DEVELOPMENT FACILITATION TEAM

Planning - Case Comments

Project Number: PR-2023-009382

Project Name: City Multigenerational Center at 10751 Cibola Loop NW

**AS-100**

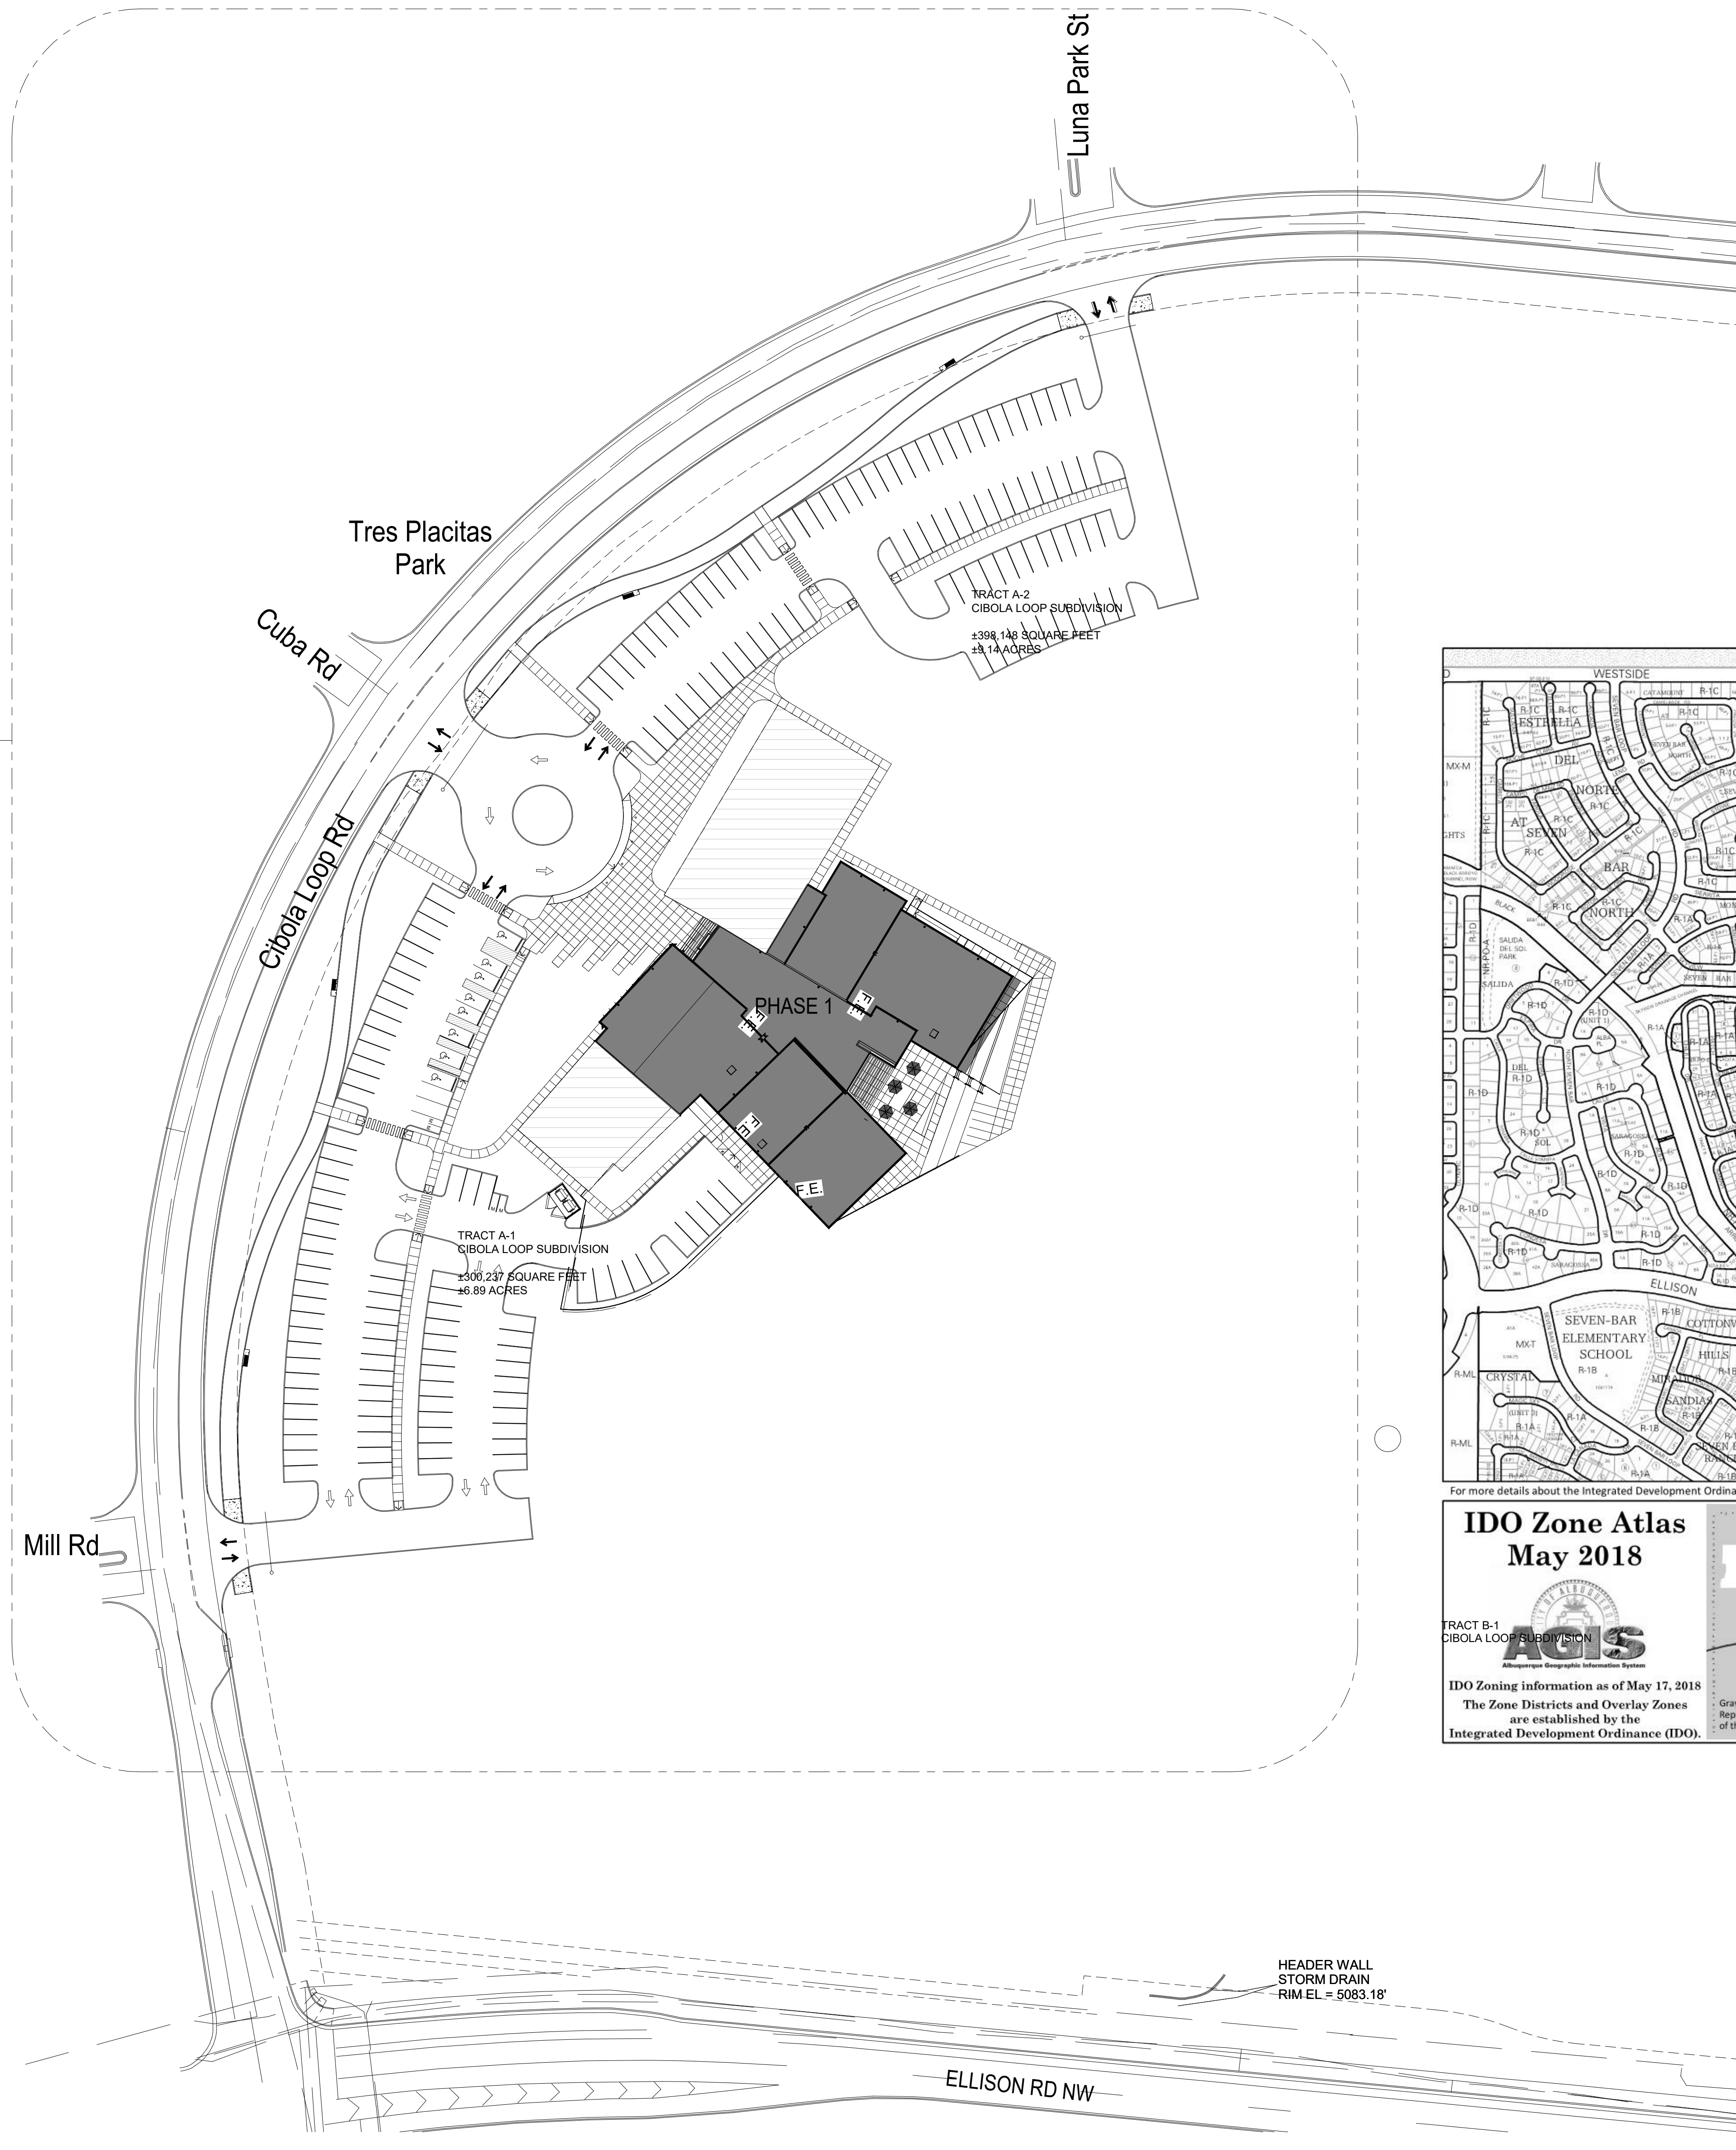
- Consider creating a more organic shape for the retention pond on the site plan in place of the rectangular pond. **Change needs to be reflected on the site plan and landscape plan.** **FBT Response:** The Site Plan sheet AS-100 has been revised to include the "organic shape." Its attached to this supplemental submittal. See also attached Sheet LP-101 for a revised drawing.
- Please provide large canopy trees along the north side of the parking lot to provide more shade on the hardscape for heat mitigation purposes. **Addressed**

**LI-101**

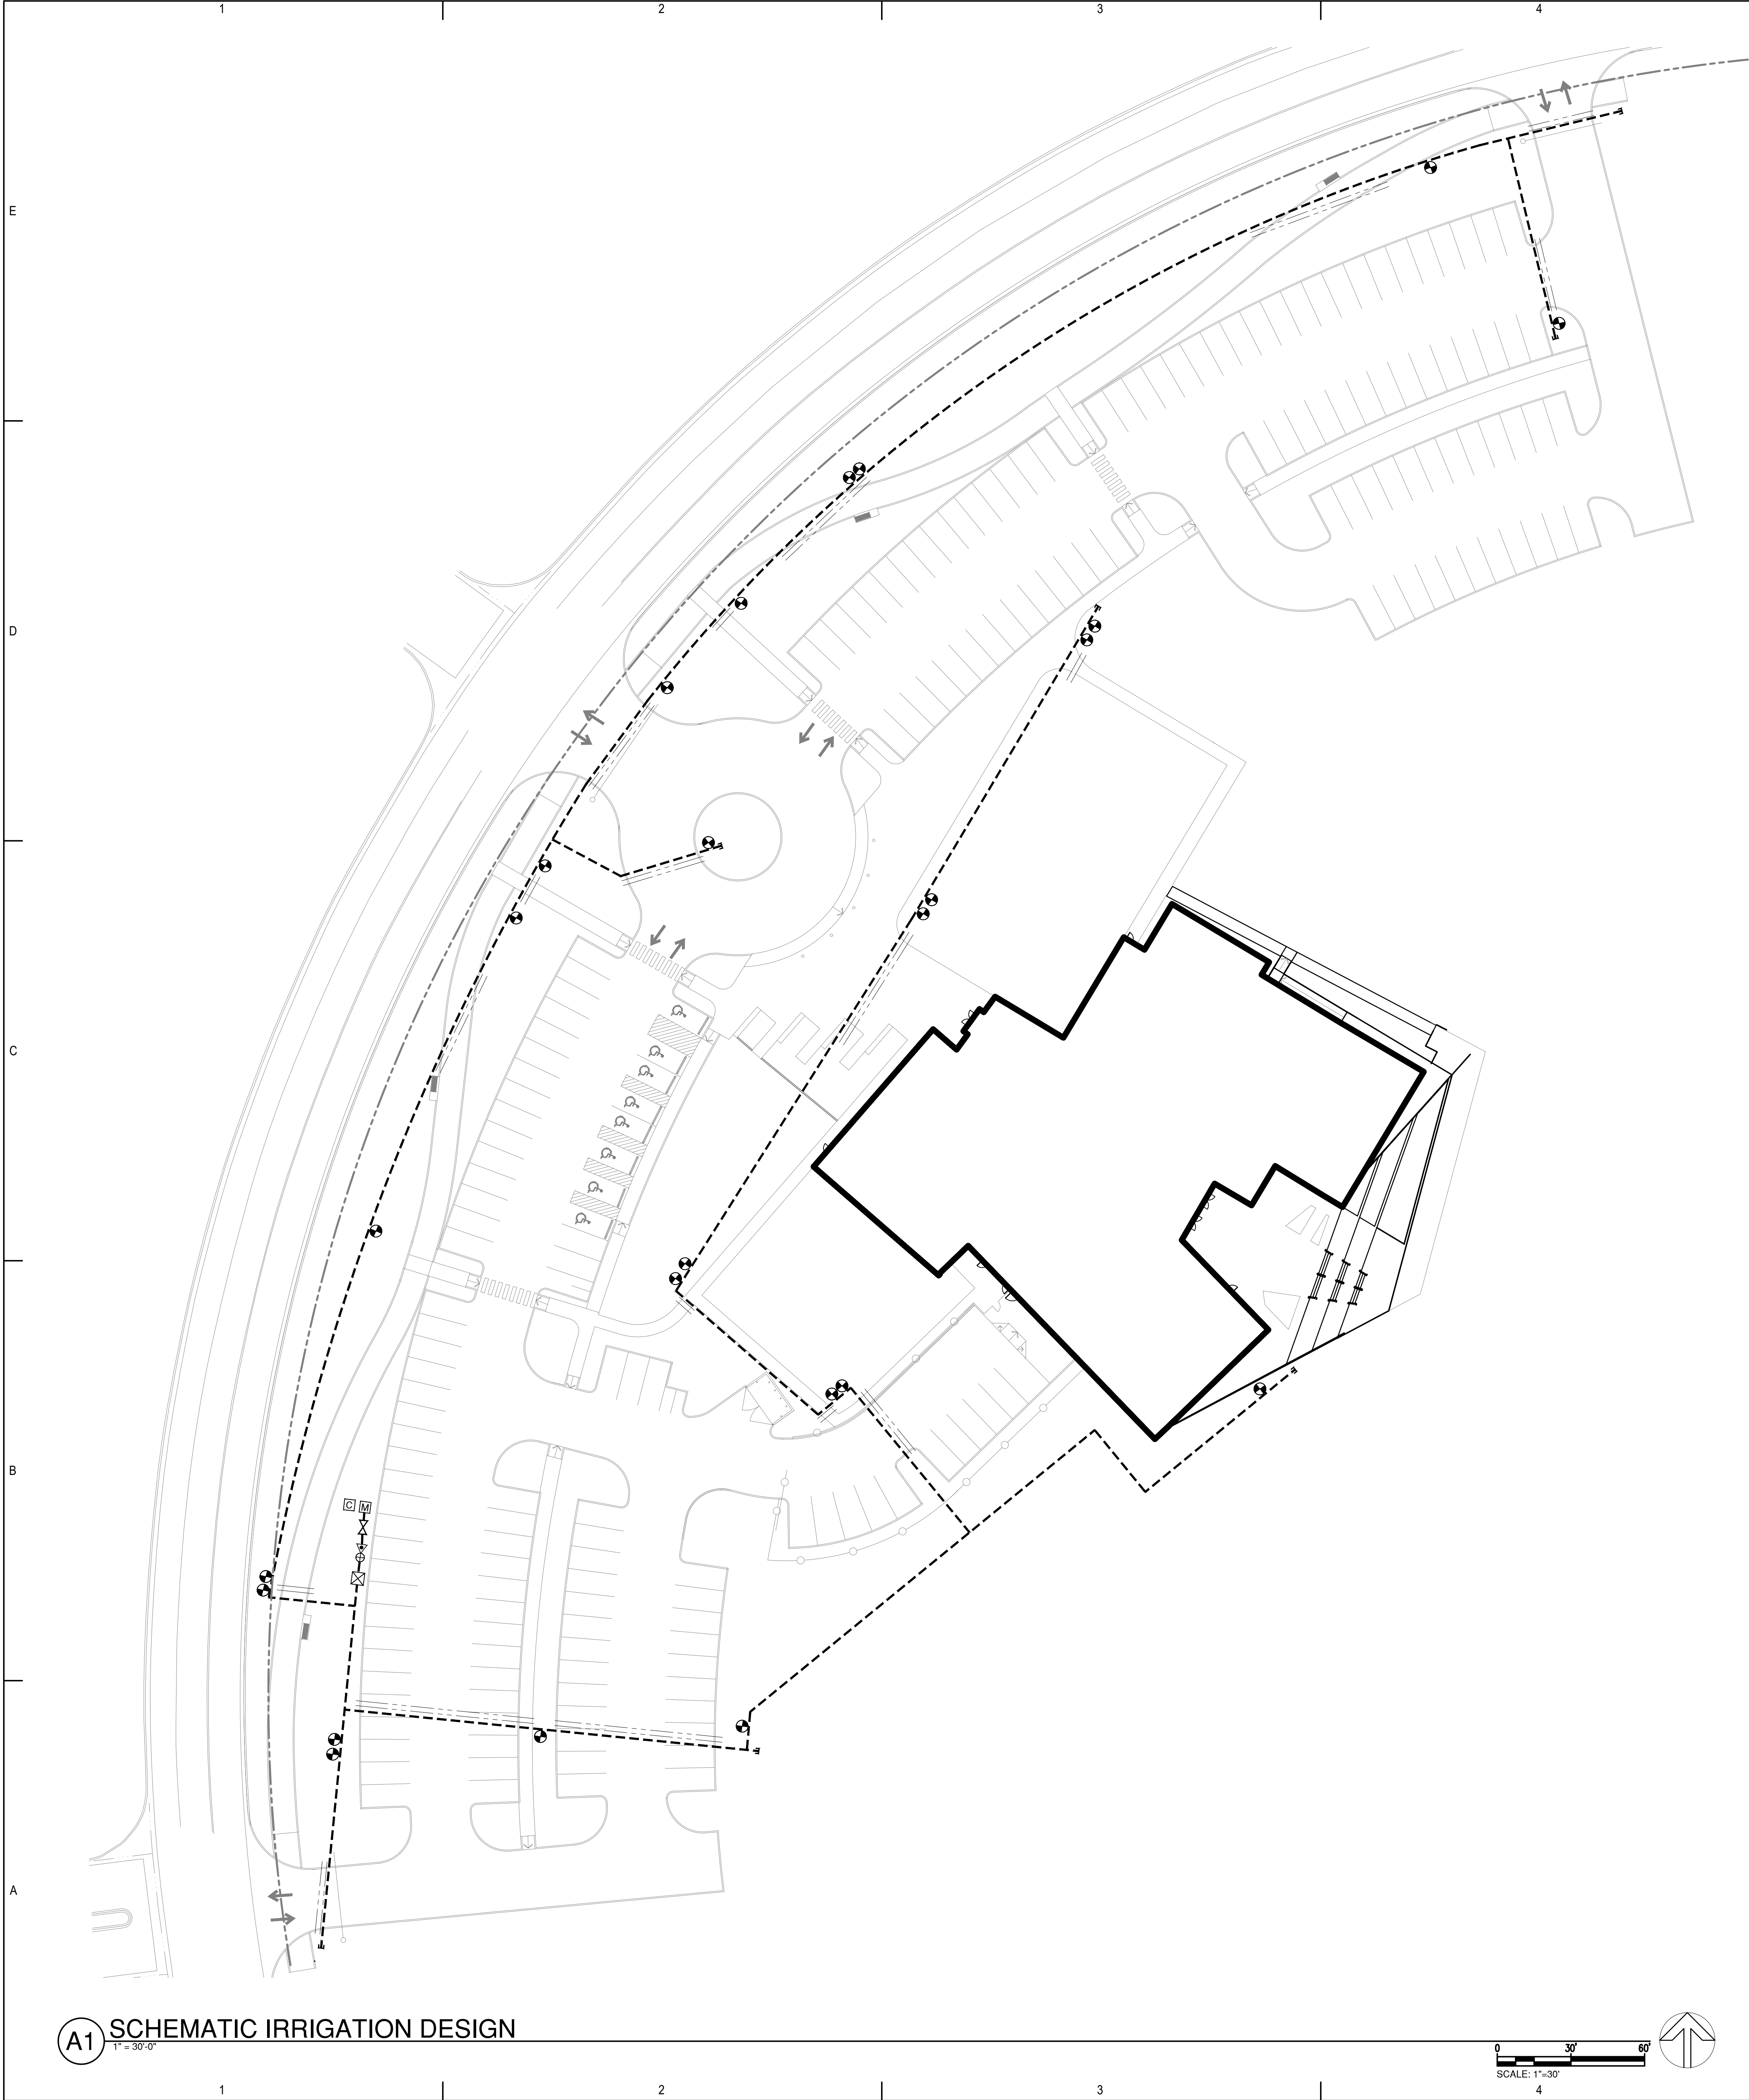
It appears that the irrigation design does not comply with this code. Please clarify or make adjustments.

FBT Response: See updated attached Sheet LP-101 for a revised drawing.

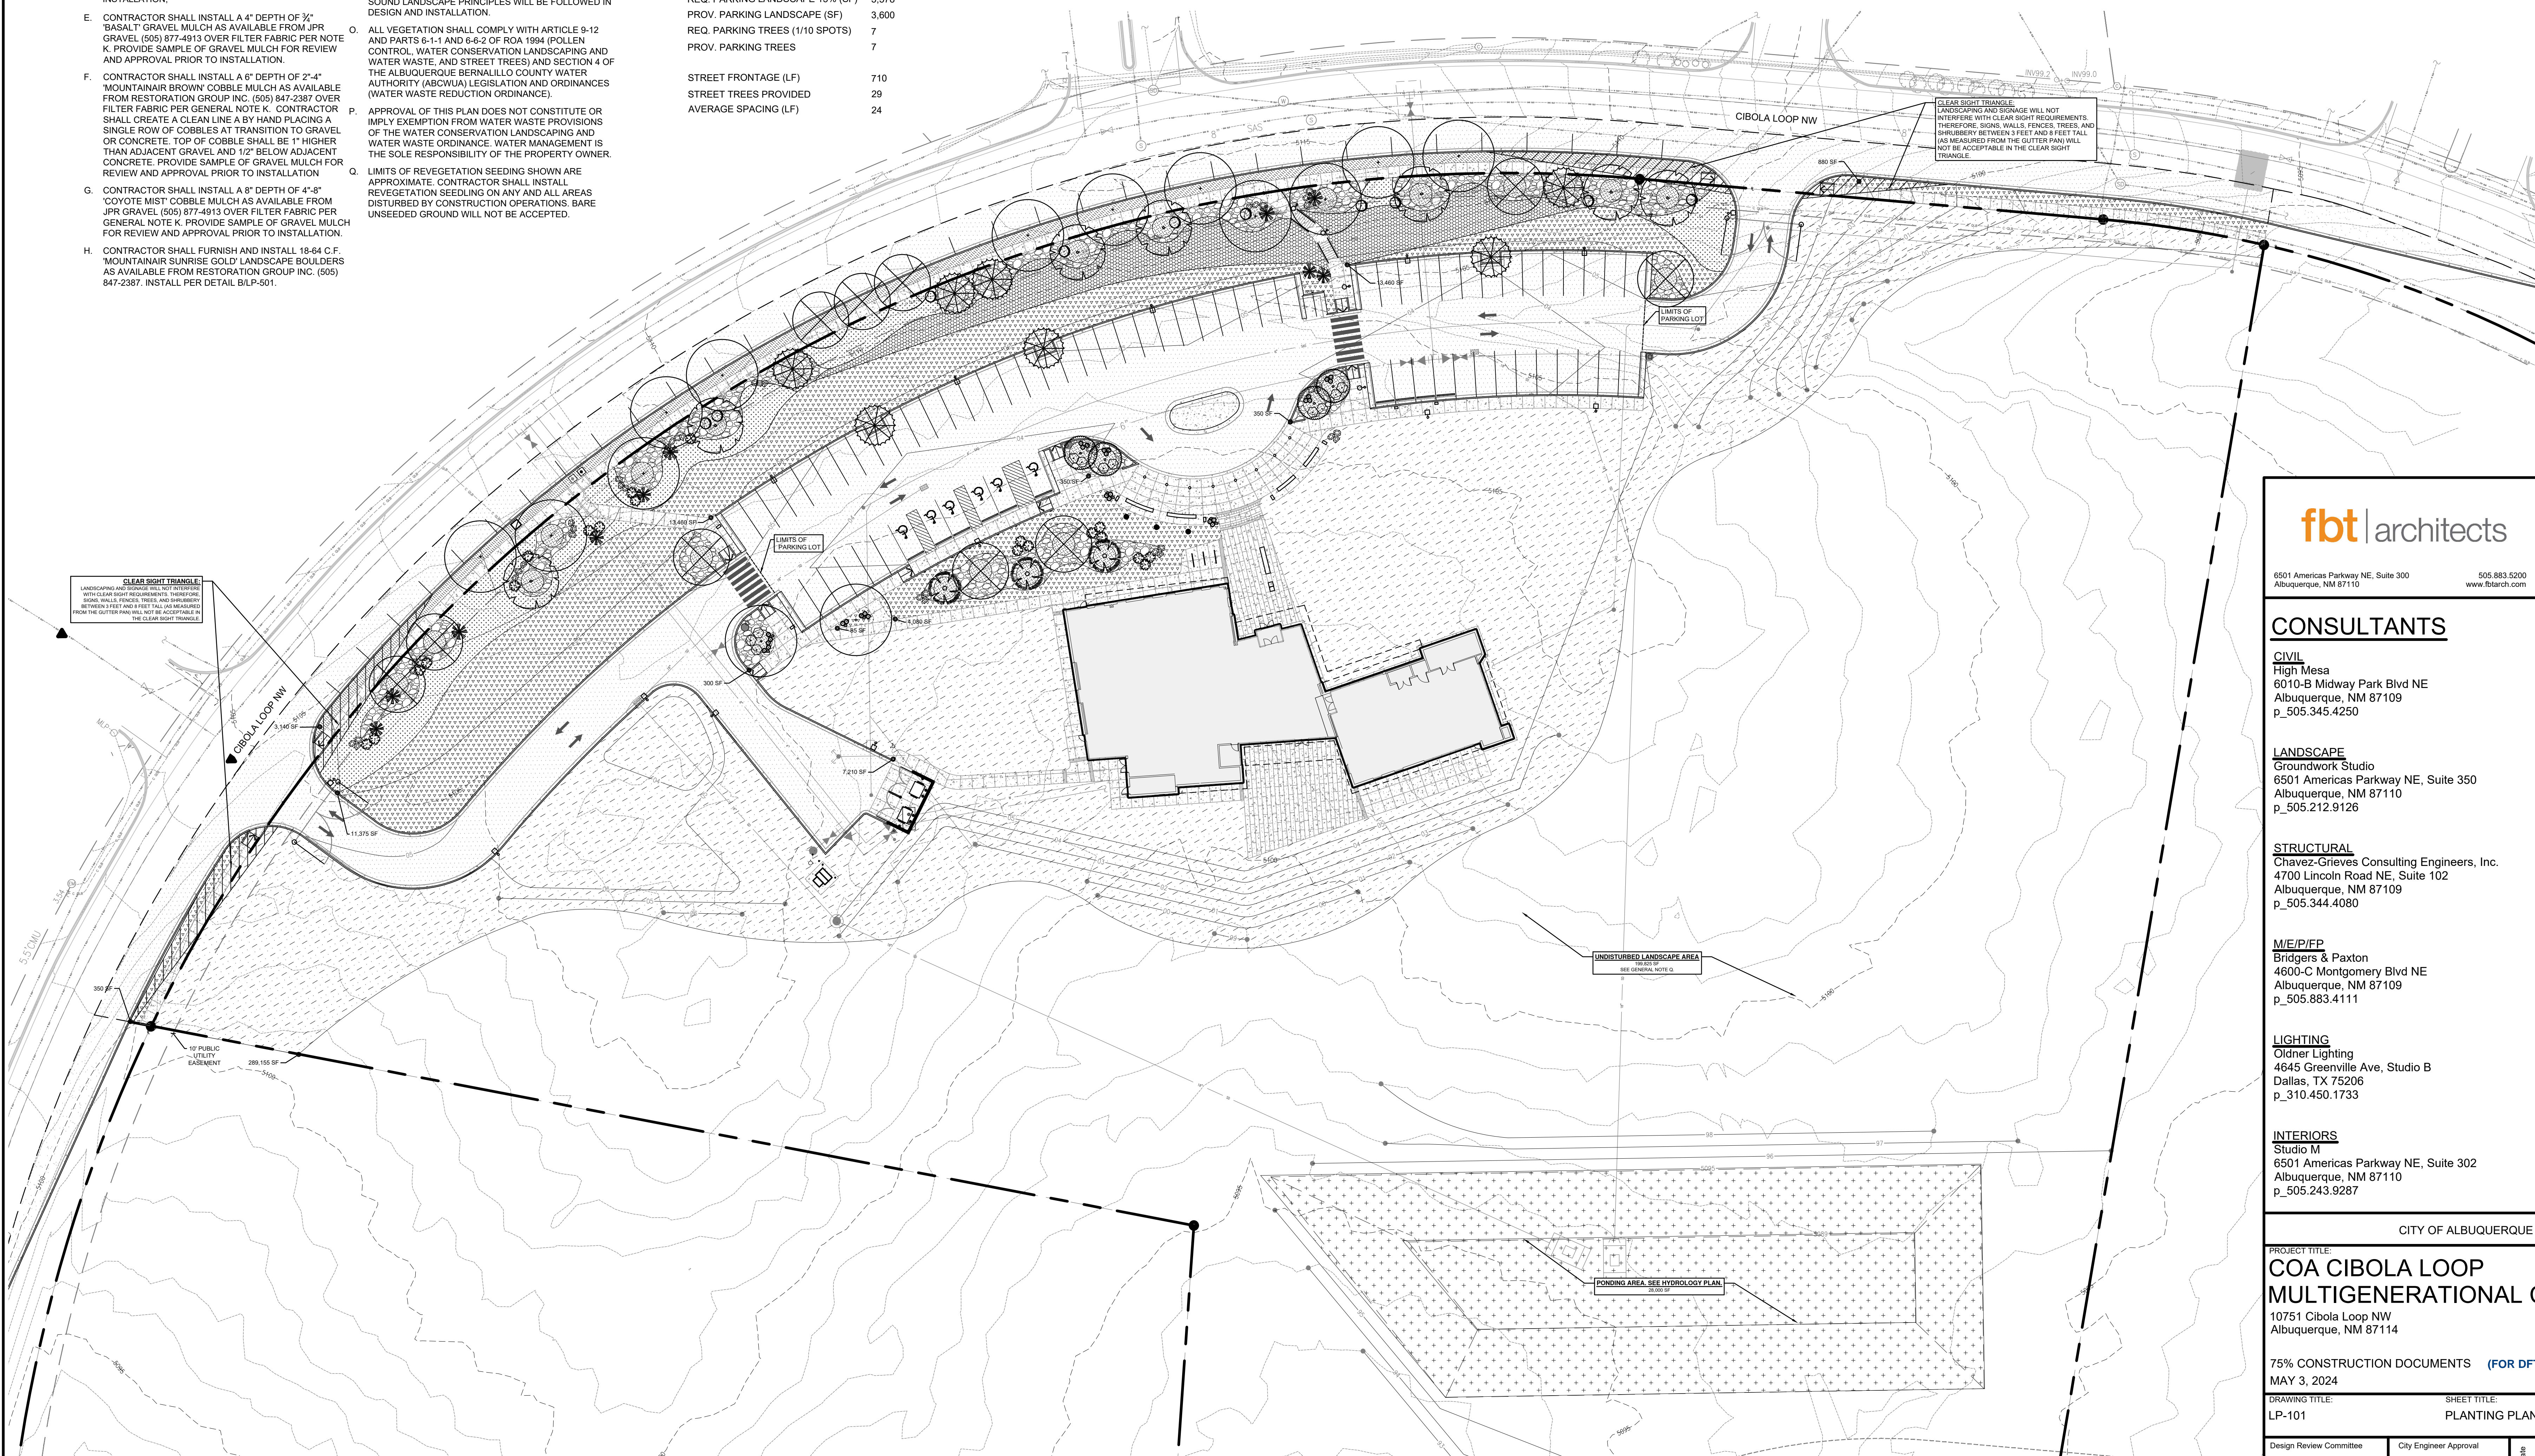
- Change the marked-up trees to provide a break between similar tree species. Please use large canopy trees like Hackberries.

FBT Response: See updated Sheet LP-101 for a revised drawing.
